My Ref: PH/1377A  
Planning Ref: 2021/93621  
Date: 3<sup>rd</sup> August 2023

**RESPONSE TO HDM CONSULTATION – DATED 29/06/2023  
ERECTION OF 12 DWELLINGS AND ASSOCIATED WORKS, LAND OFF FULWOOD DRIVE,  
GOLCAR, HUDDERSFIELD, HD7 4JH**

Description: PROPOSED SITE PLAN & 3D VIEW

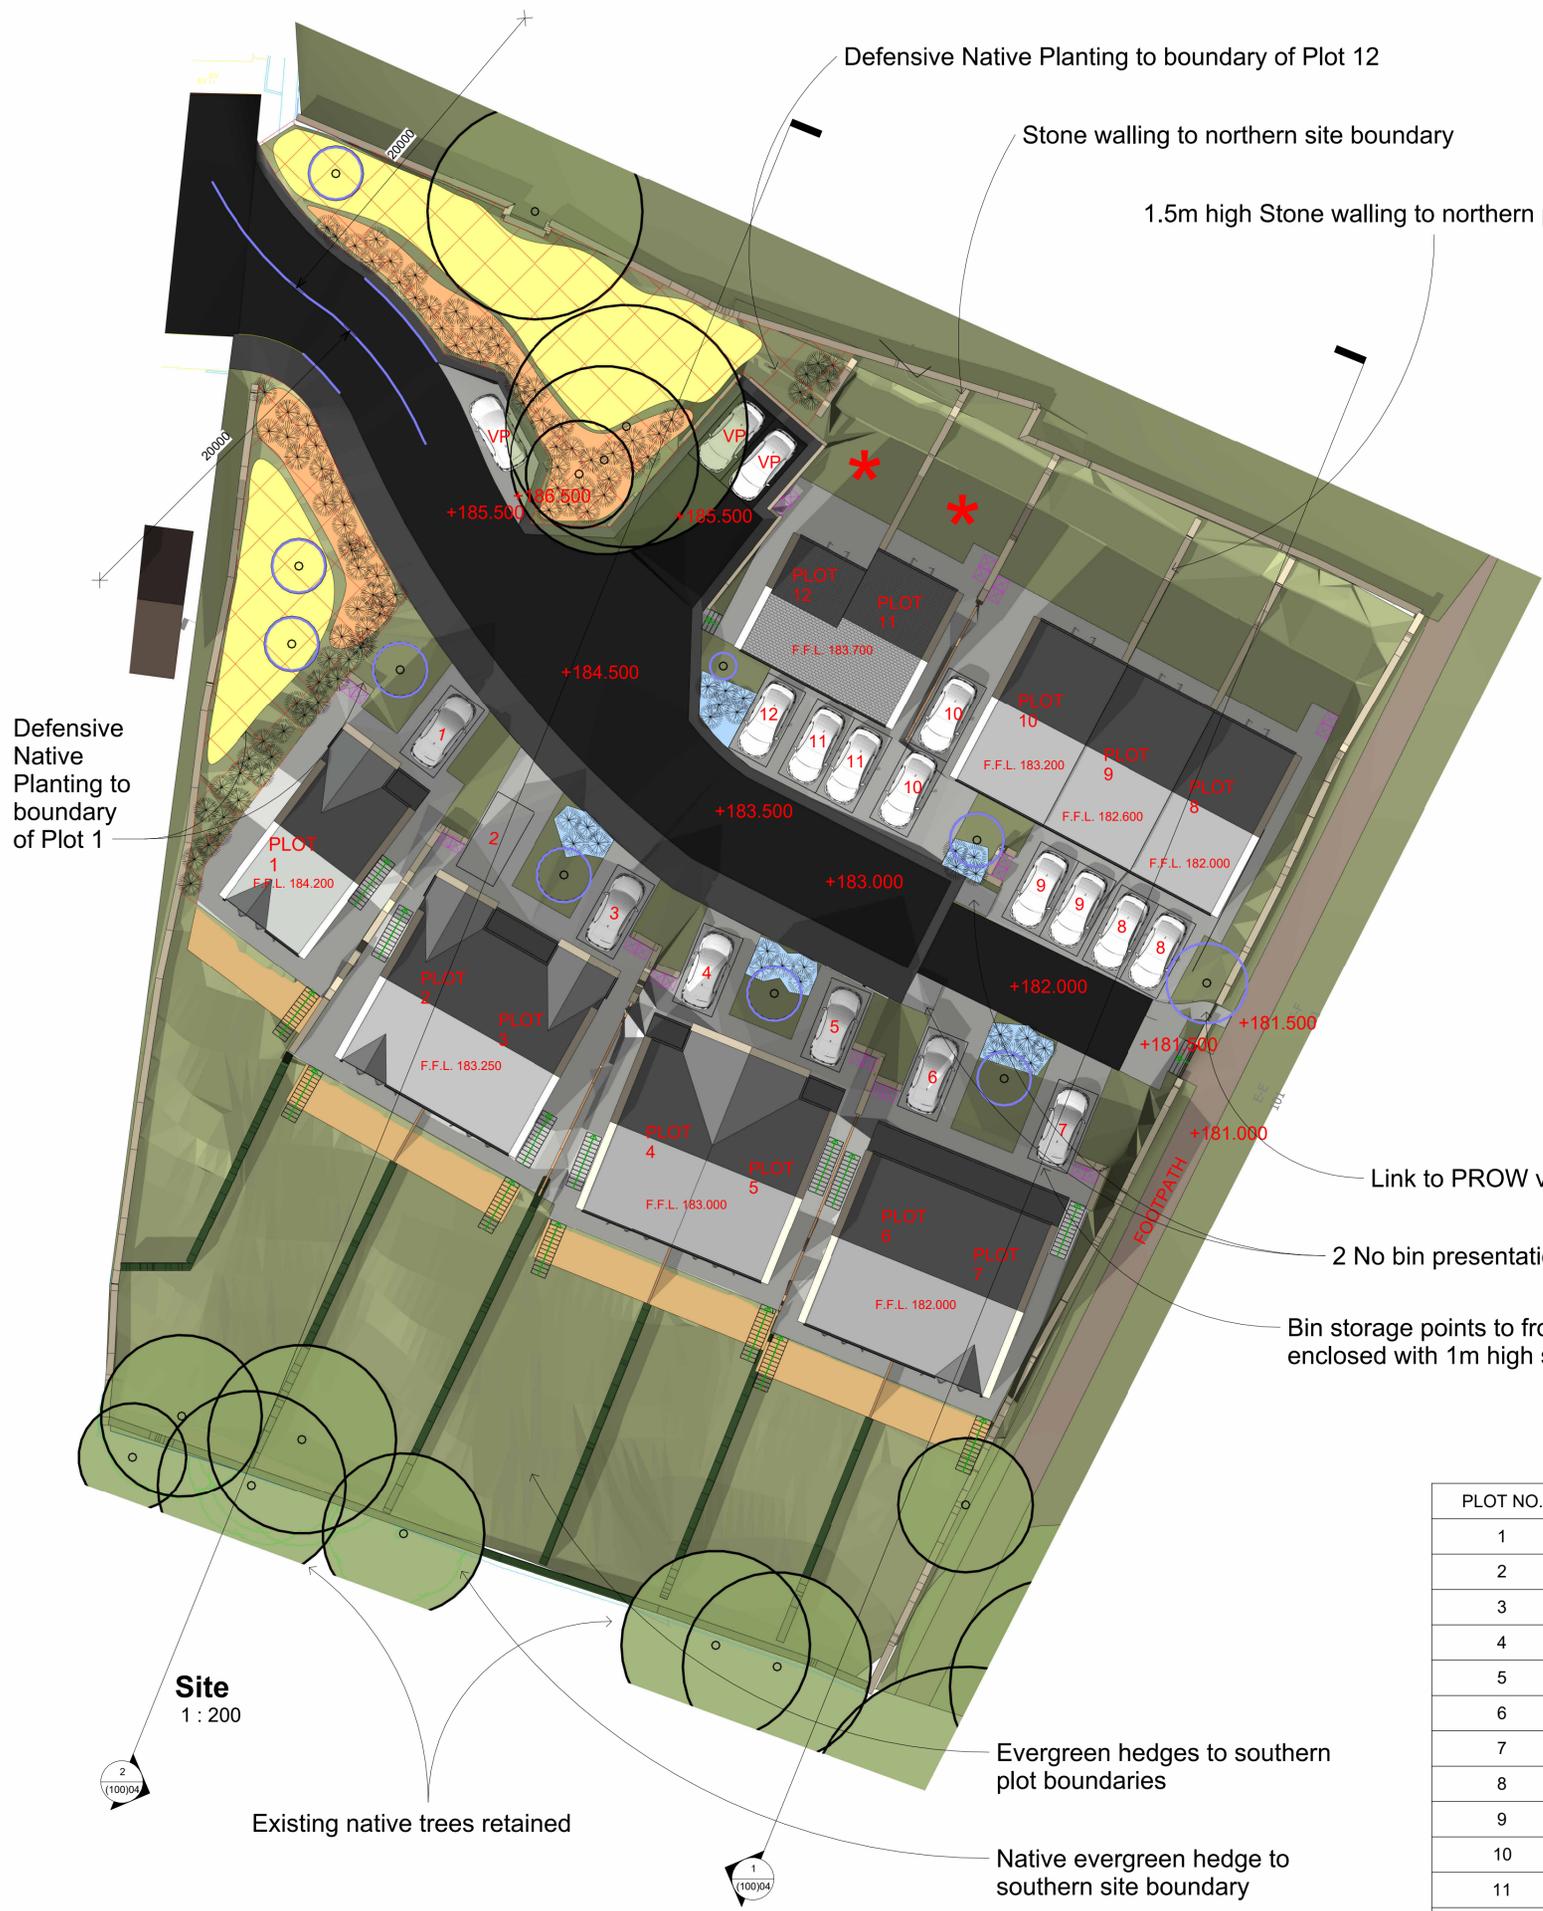
**Concerns have been raised in respect to the access location off Fullwood Drive, with an uncomfortable manoeuvre for larger vehicles.**

**The curve immediately after the junction appears to have a centreline radius greater than that requested by local guidance.**

**Concerns relating to car parking provision for plots 11 and 12.**

**Concerns relating to visitor parking provision adjacent to plot 12, possibly being used by the occupiers of plots 11 and 12. The visitor parking may also cause adoption issues.**

The swept path analysis shows that a 11.22m refuse collection vehicle can negotiate the proposed access. The access has been amended to include a radius on the north side as it meets Fullwood Drive and also identifies a continuation of the south side footway that proceeds within the site. The amended access and vehicle tracking is shown on the drawing attached.

The proposed adoptable internal road provides a hybrid shared surface with a footway along the south side only. The shared surface street is classified as a 'Type C' street where the centreline radius is determined by using vehicle tracking. The layout plan approved at outline (planning reference 2017/93638) contained a similar centreline radius. The plan attached shows that the centreline radius is suitable and compliant with Kirklees Council's Highway Design Guide.

The proposals have been amended to so that plot 12 will have one bedroom only. The key design driver 20 within the Council's Highway Design Guide requires 2 spaces for those dwellings with 2 or 3 bedrooms, with no provision specified for 1 bedroom dwellings. Therefore, the off street car parking provision is considered to be suitable and compliant with the key design driver.

As above, plots 11 and 12 and remaining plots contain suitable off street parking in accordance with key design driver 20. Therefore, it is considered that the visitor spaces would be used by visitors to the site and not the residents of plots 11 and 12. The visitor spaces are contained within the adoptable highway (surrounded by the adoptable hard margin) and should not cause issues with the future road adoption process.
